Your ref: SSD 17352813
File no: MC-21-00001

**SSD 17352814 – Huntingwood Processing Facility Expansion – 65
Huntingwood Drive, Huntingwood**

Blacktown Council's submission to SSD 17352813 – Huntingwood Processing Facility Expansion

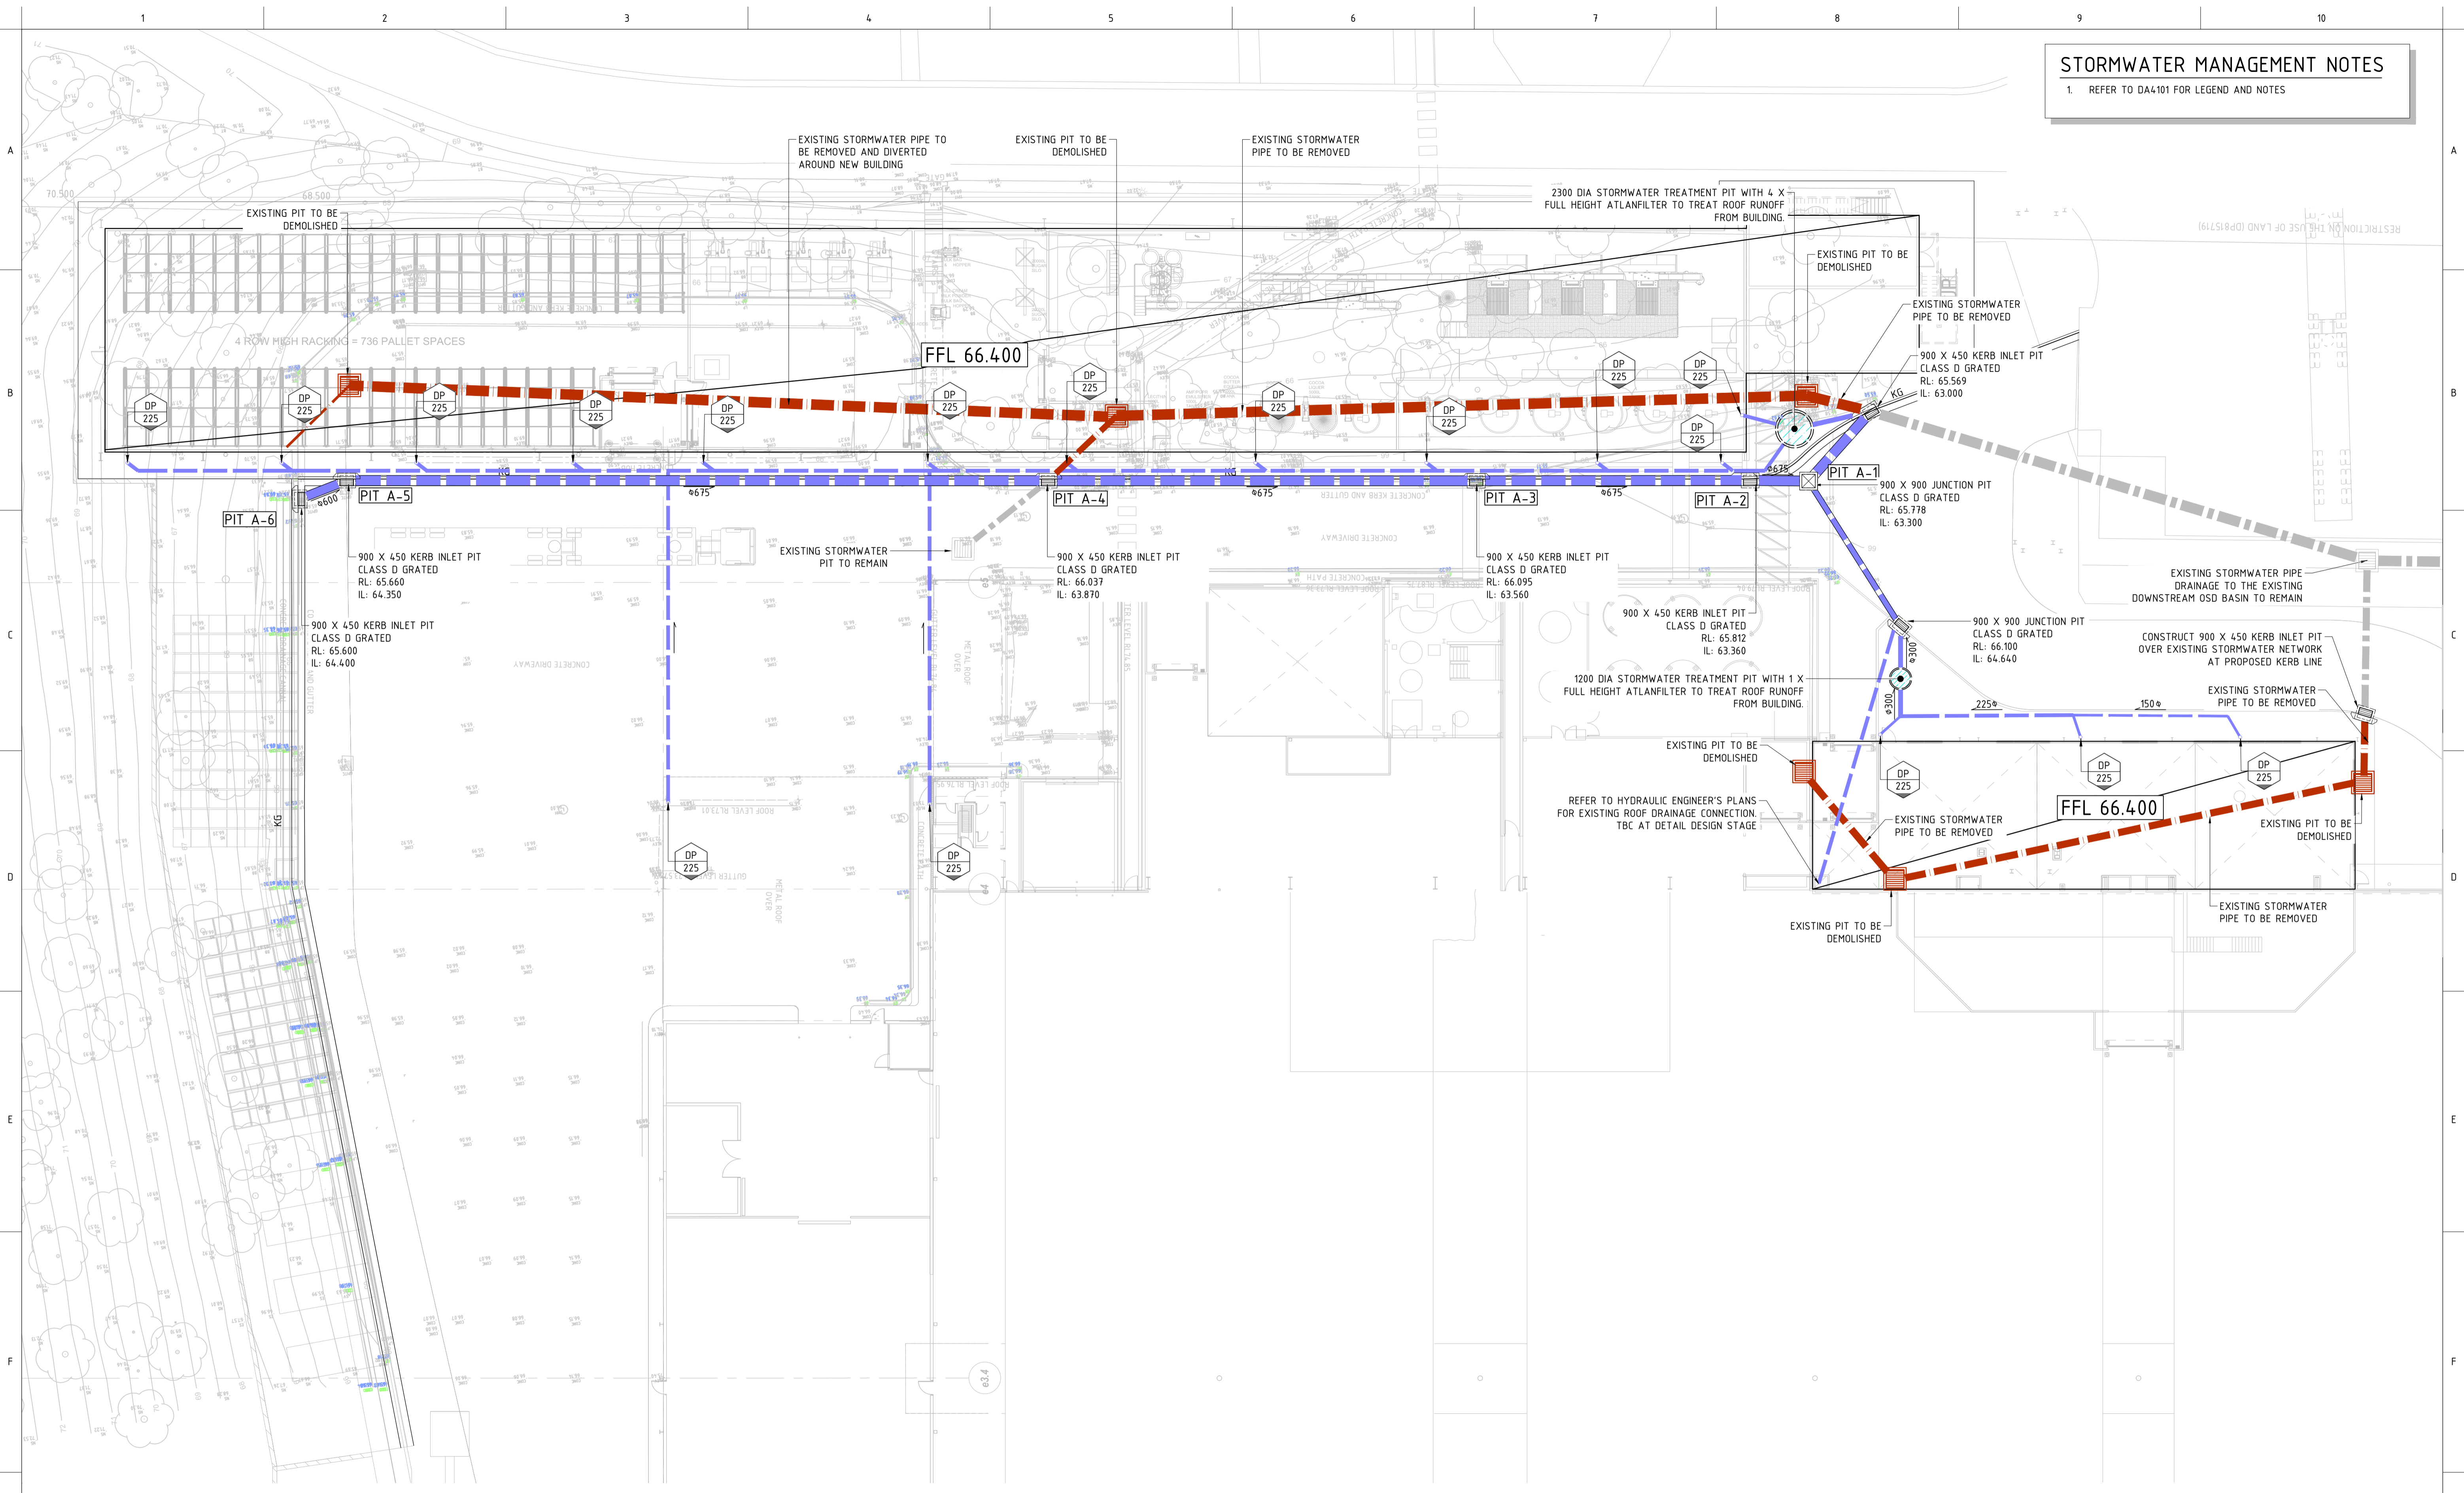
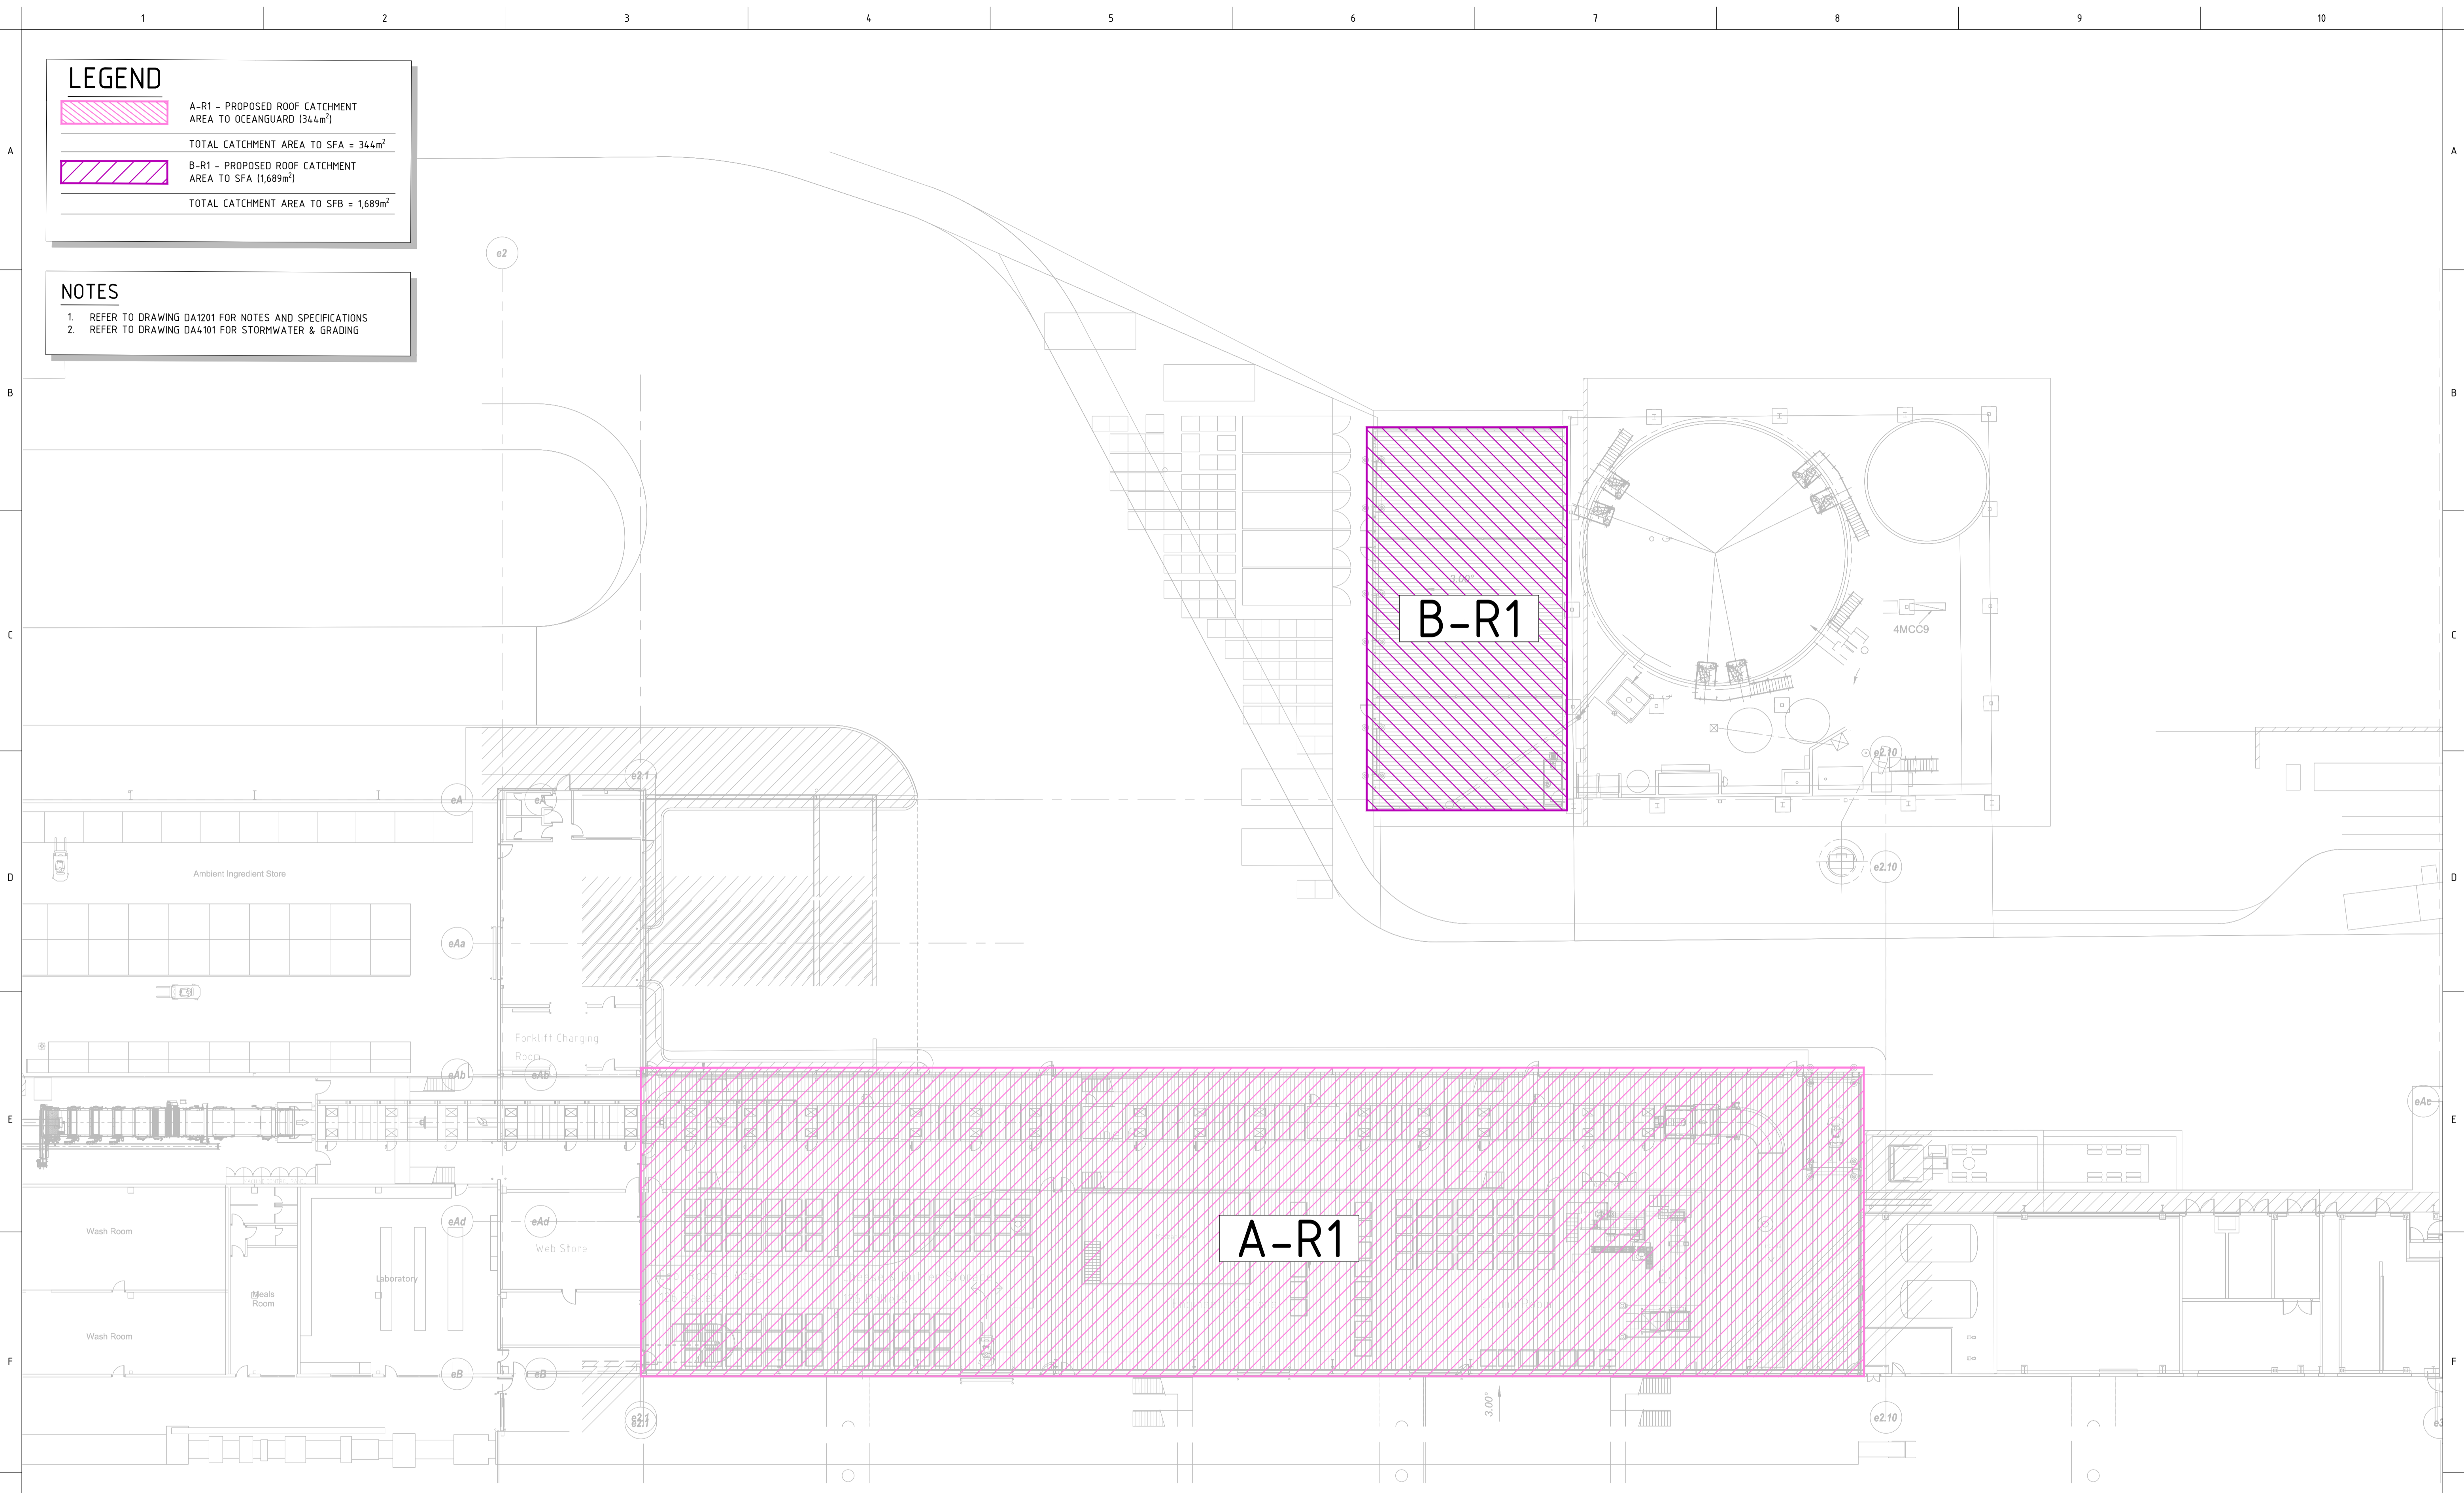
- a. Tertiary treatments in series are not permitted.
 - Provide separate and total catchments for each Jellyfish.
 - Provide the complete jellyfish calculations as per the WSUD developer handbook chapter 12.13 and in particular 12.13.3.
 - The jellyfish levels are not as per 12.13.3. inlets and outlets are to be set at different levels.
 - Provide the 1EY HGL for the jellyfish calculations.
- b. Revise stormfilter designs and catchment plans as a result.
- c. Provide invert levels of drainage network and ensure that backwater levels from proprietary systems are considered.
- d. Submit amended plans and updated MUSIC (standard) model.
